21.04.22

3No. flats at Stirling Spiritualist Church, 27 King Street, Stirling - 22/00008/FUL

PLANNING APPLICATION	
	Emma Gallagher	
	27 King Street, Stirling	
	Title: Proposed Layouts	
	Drawing Number: 22/KS/02	
Scale: 1:50/100 @ A1		
Date: January 22		
<small>233 Grahamsdyke Street Laurieston, FK2 9NA 0772 0772 636 barry@fk1design.co.uk</small>

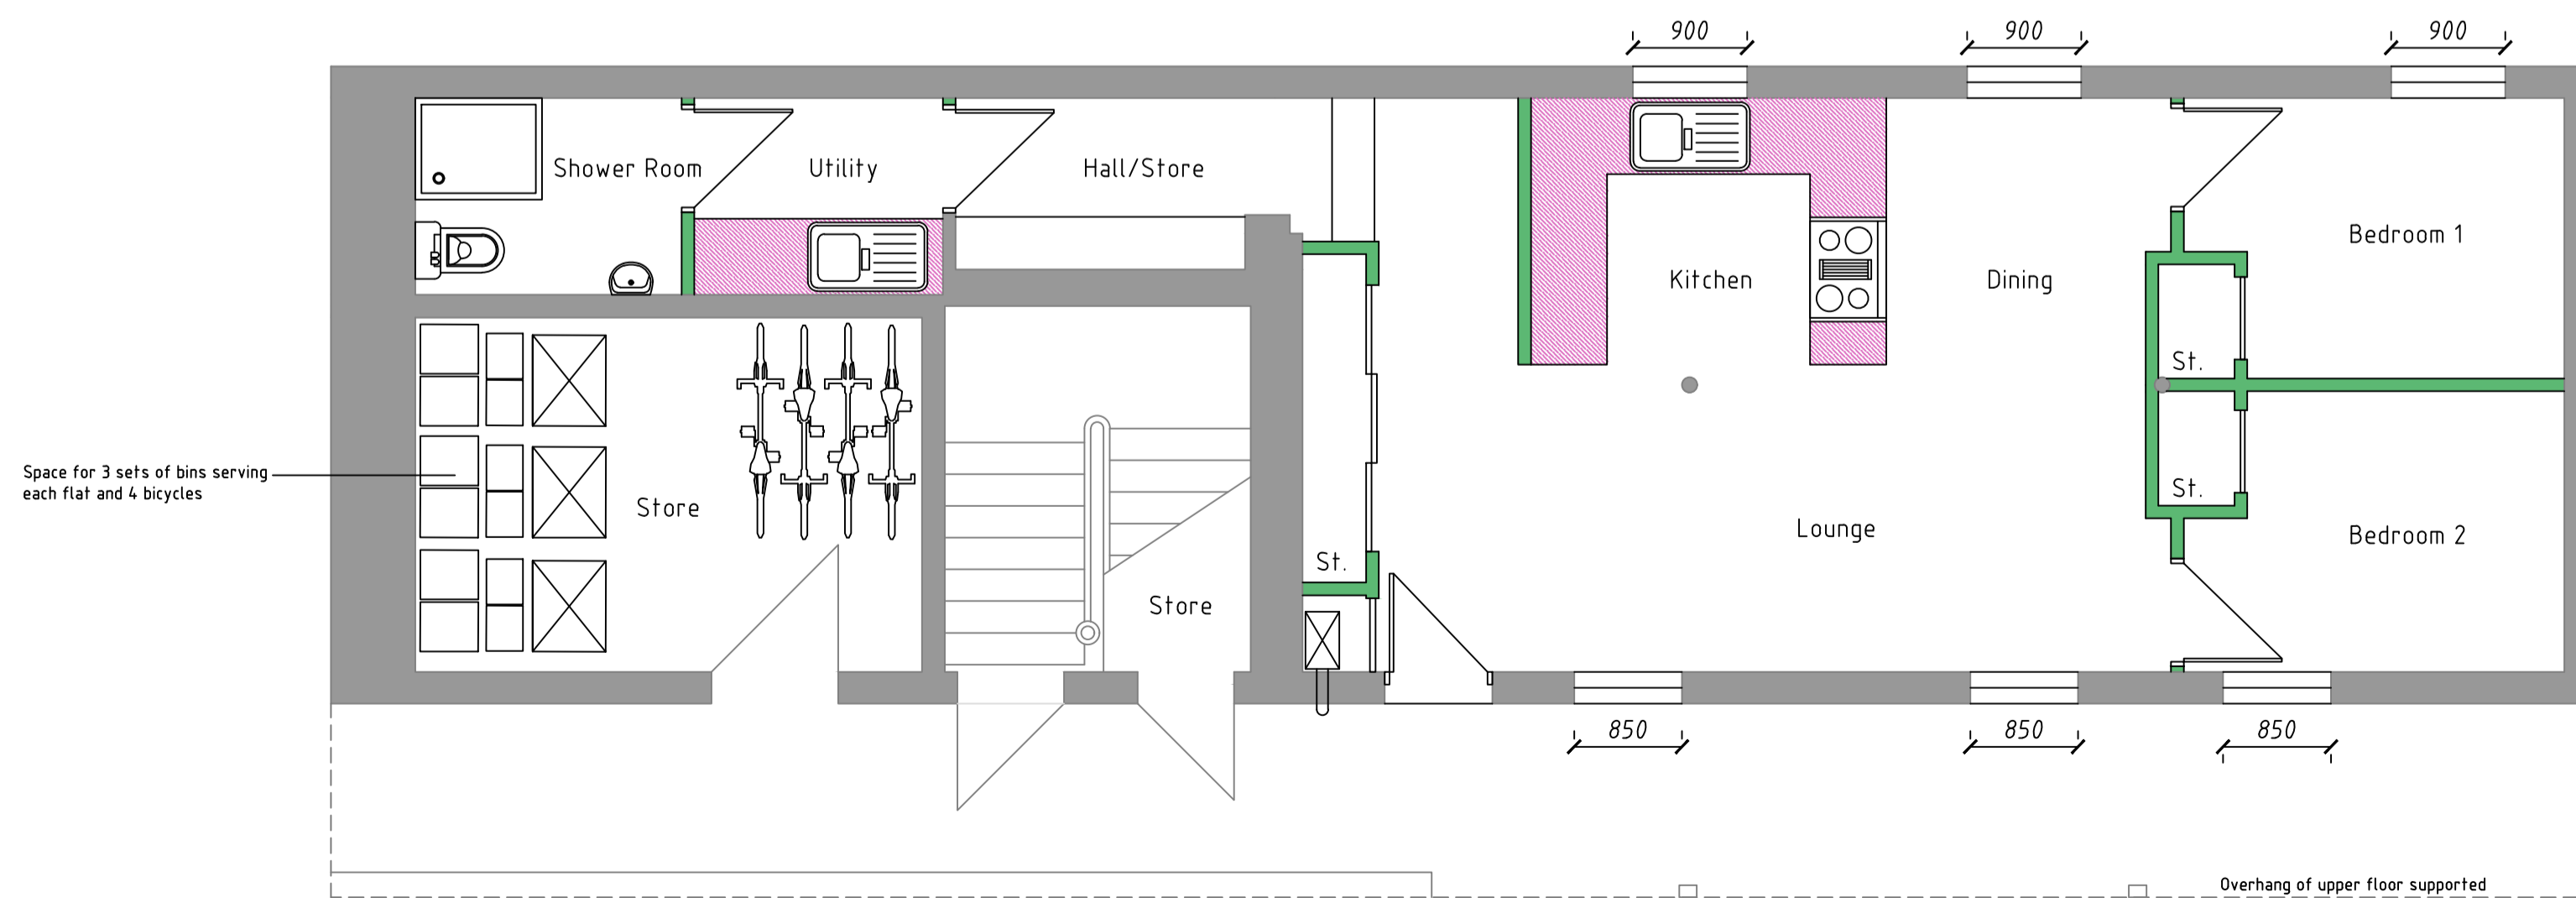
Further to the submission of the Section 42 application I can confirm that the bin and cycle store will now be wholly within the existing storage area of the existing building as indicated on the Proposed Layouts drawing.

No part of the proposed works will therefore take place to the rear of the building.
